APPENDIX D – ENGAGEMENT SUMMARY TABLE

STORMWATER MANAGEMENT DETAILS - SHEET 03

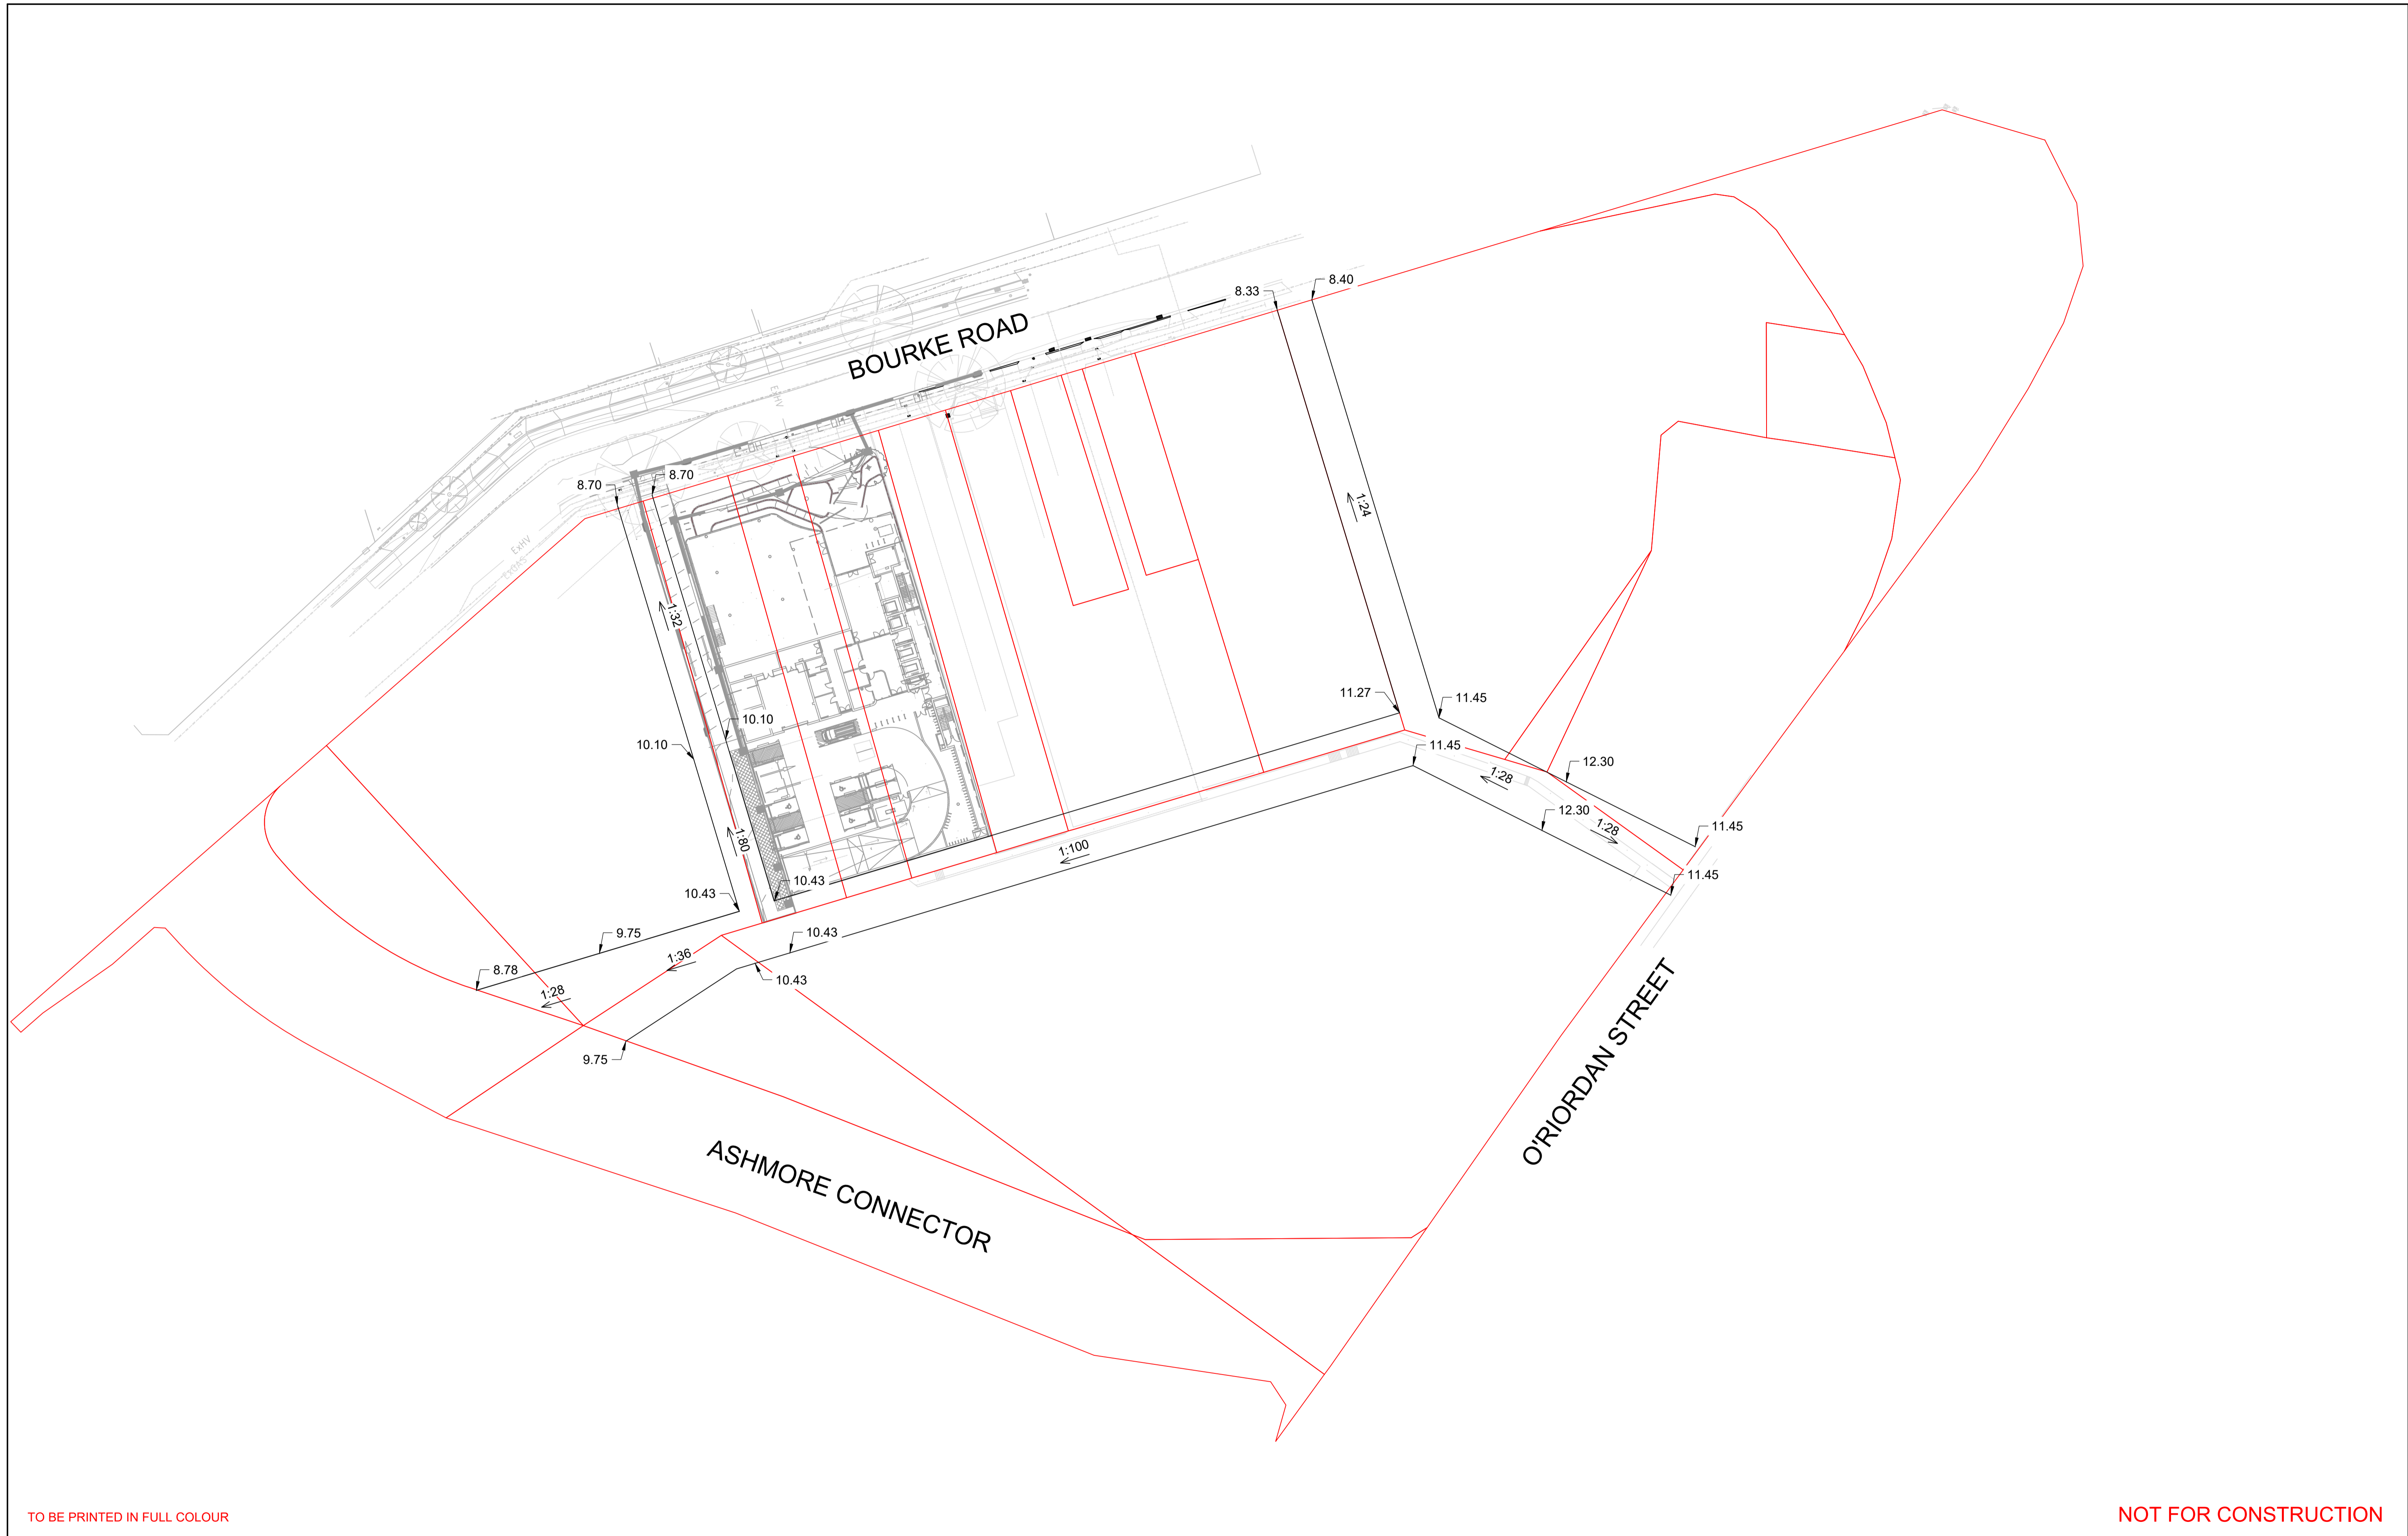
<p><i>Stormwater</i></p> <p>Council does not support the proposed drainage line that runs along the</p>	<p>The proposed stormwater plan has been revised and the public domain stormwater pipe no longer enters back into the site, refer to the</p>

Stakeholder	How this group was consulted	Feedback	Project response
		<p>property boundary and then enters back into the site. Stormwater should be located solely on the public domain.</p> <p><i>Other Comments</i></p> <p>Explore opportunities to 'open up' the pedestrian entry way.</p> <p>Seek to place bed heads closer to the windows in the rooms where possible.</p> <p>Ensure waste storage (especially bulky waste) is maximised in the development.</p> <p>The Social Planning Team reiterated the importance of ensuring the development co-exists with any future health/medical facilities that are being provided in the redevelopment of Waterloo South.</p>	<p>plans within the Water Cycle Management Plan at Appendix AA.</p> <ul style="list-style-type: none"> ▪ The elevated landscape podium invites the community into the site, while protecting the building from flood risk. ▪ The bedheads are designed to have views to windows where possible. ▪ The Waste Management Plan (Appendix FF) confirms that ample waste storage is provided. <p>The SIA has considered the impacts of the proposed development in the context of the broader health network, including existing and future health services, refer to Section 6.2.7 and Appendix JJ.</p>

Drawing Title
LEVEL 04 GENERAL ARRANGEMENT PLAN

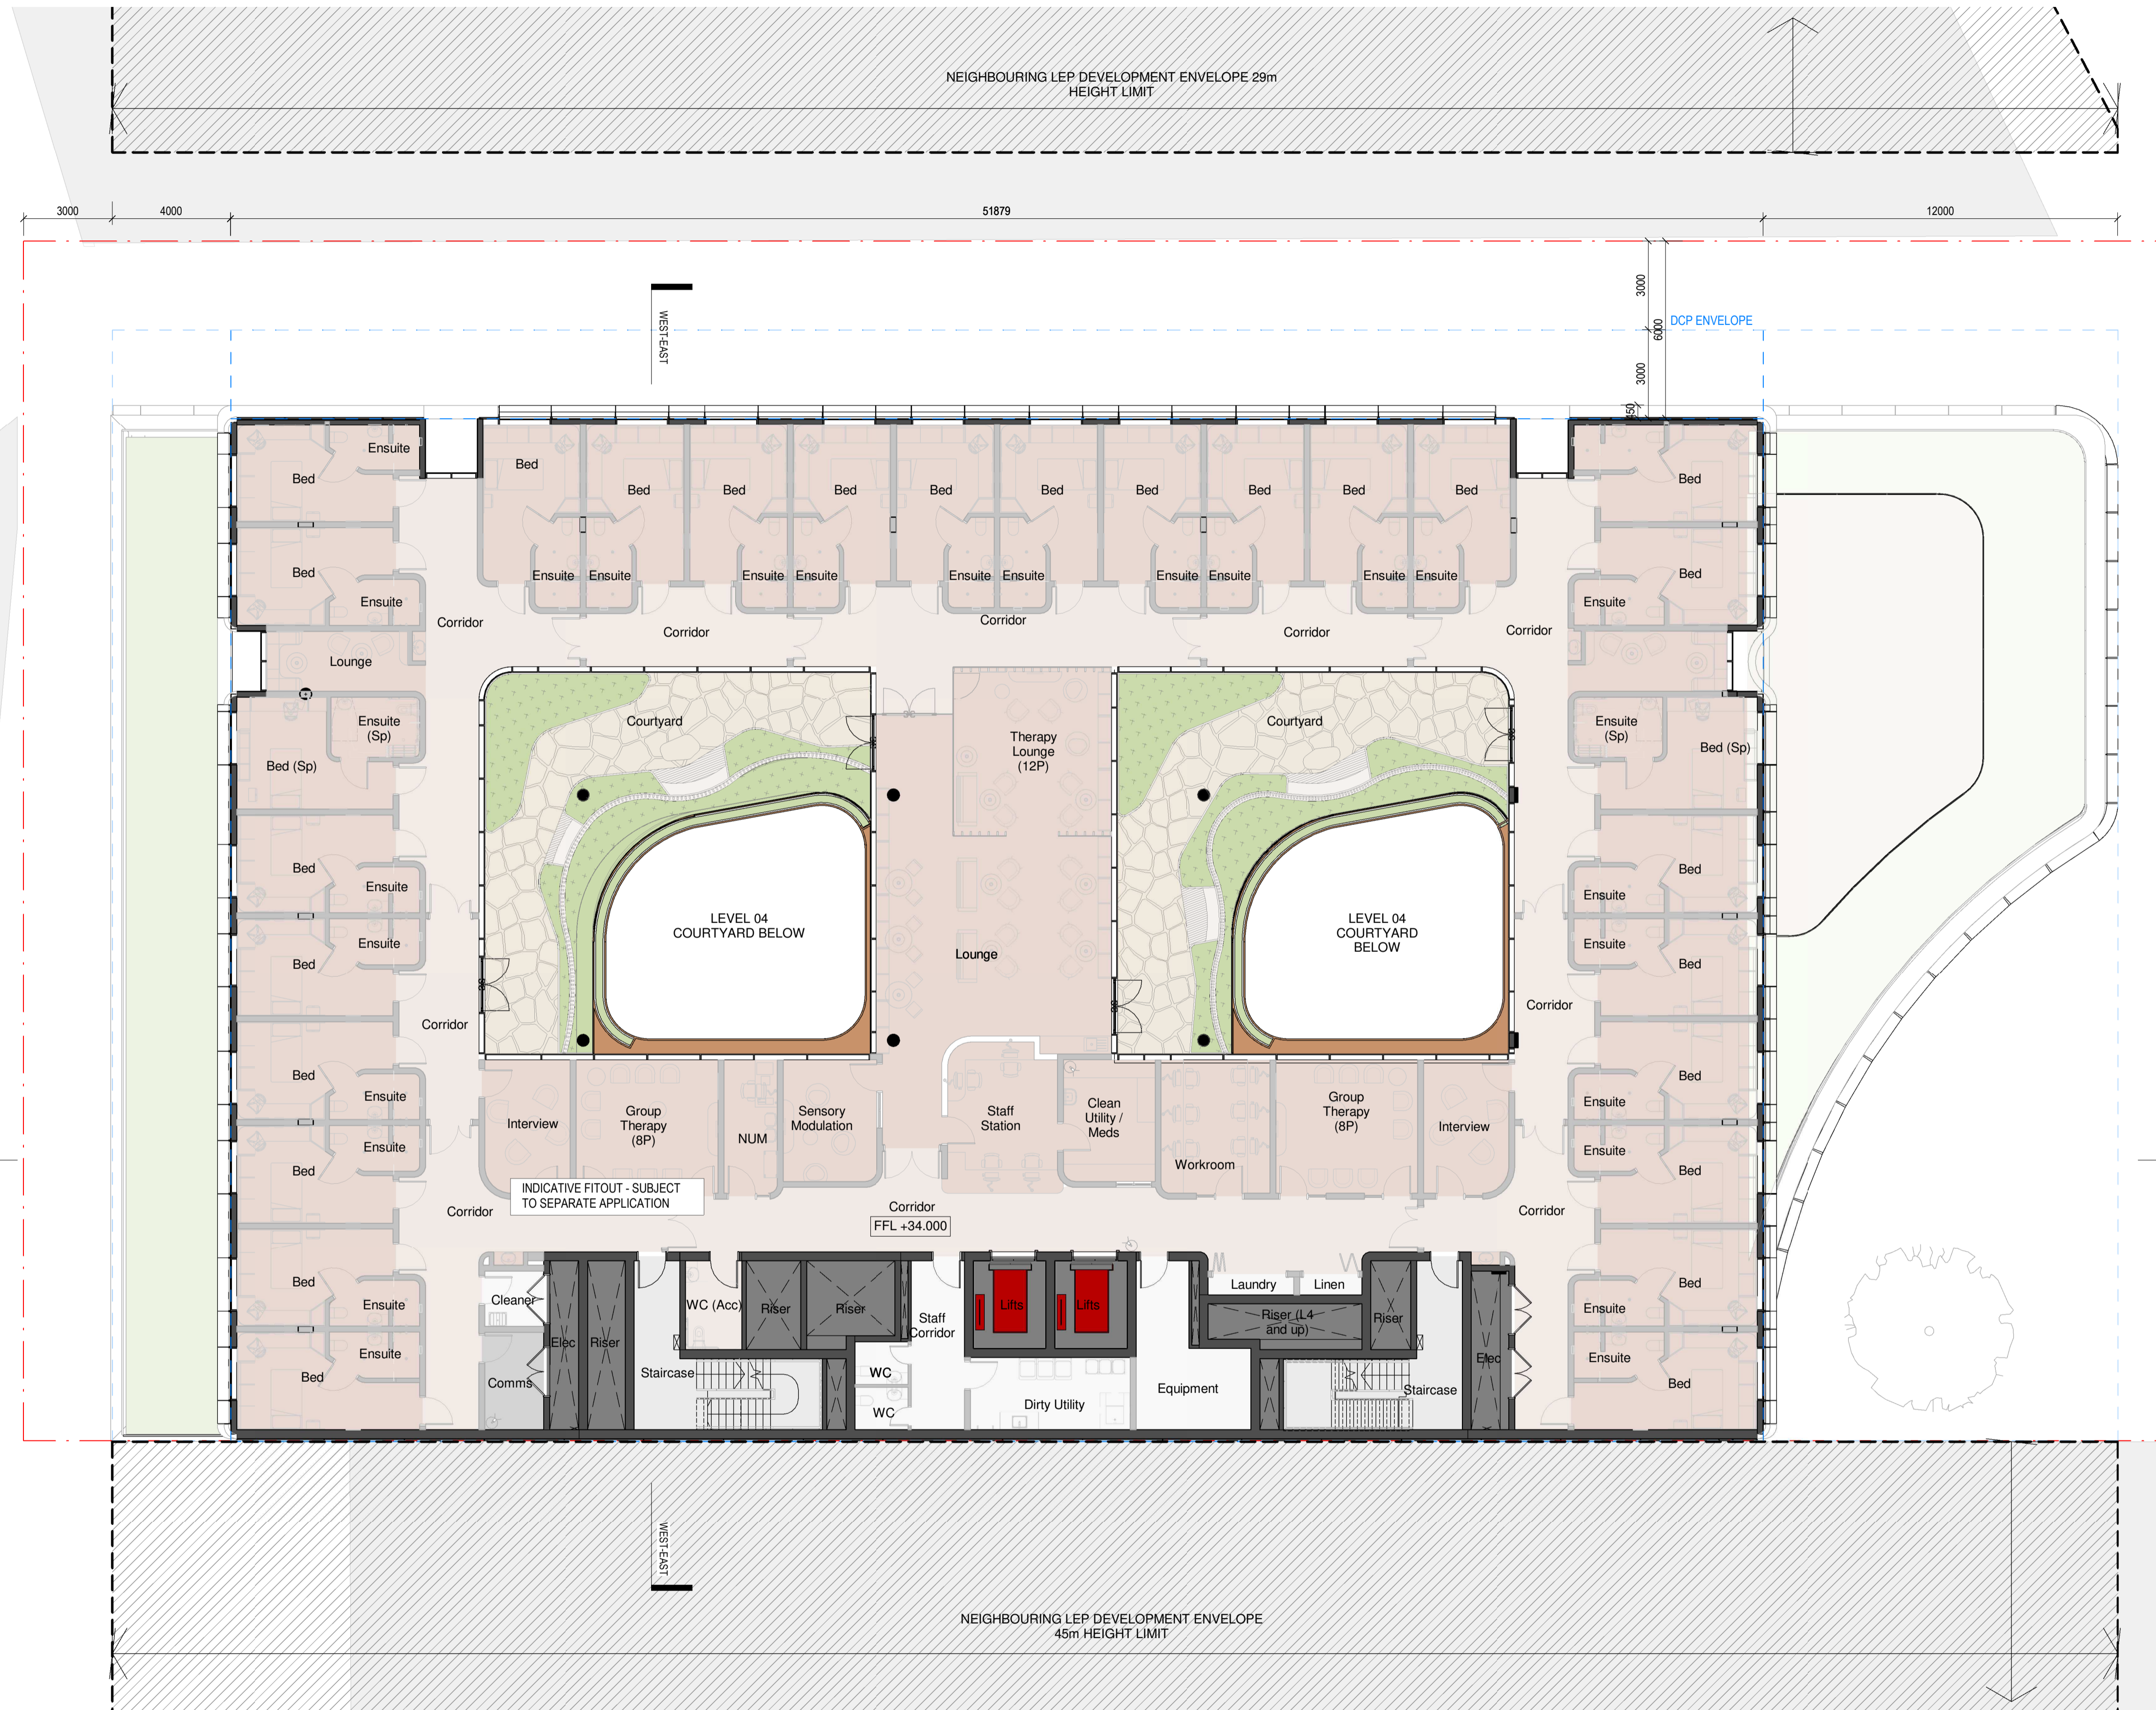
Stakeholder	How this group was consulted	Feedback	Project response
		<p>Include a gate on the balustrade on the level 4 podium so planting can be accessed/maintained.</p>	
		<p><i>Laneway Design</i></p> <ul style="list-style-type: none"> ▪ Council has strategic documents which detail specific requirements for paving materials, lighting etc. <p>The DCP envisions a one-way northbound arrangement however, Council is open to further discussions about a counterclockwise movement of traffic.</p>	<p>The proposed laneway has been designed in accordance with the Sydney Streets Code 2021 and the Public Domain Manual 2021.</p> <p>The proposed development seeks to deliver the identified DCP laneway along the western and southern boundary of the site. In the short term, the 6m wide laneway will allow for two-way movement. Following the competition of the laneway, it is anticipated that a one-way laneway would be delivered to allow for manoeuvring space for two vehicles to pass.</p> <p>To ensure minimal travel time to the site for ambulances in the event of an emergency, it is proposed that the one-way arrangement would follow an anti-clockwise direction. The swept paths prepared by Positive Traffic demonstrate the safe and efficient flow of traffic in an anti-clockwise direction in the future laneway scenario.</p>
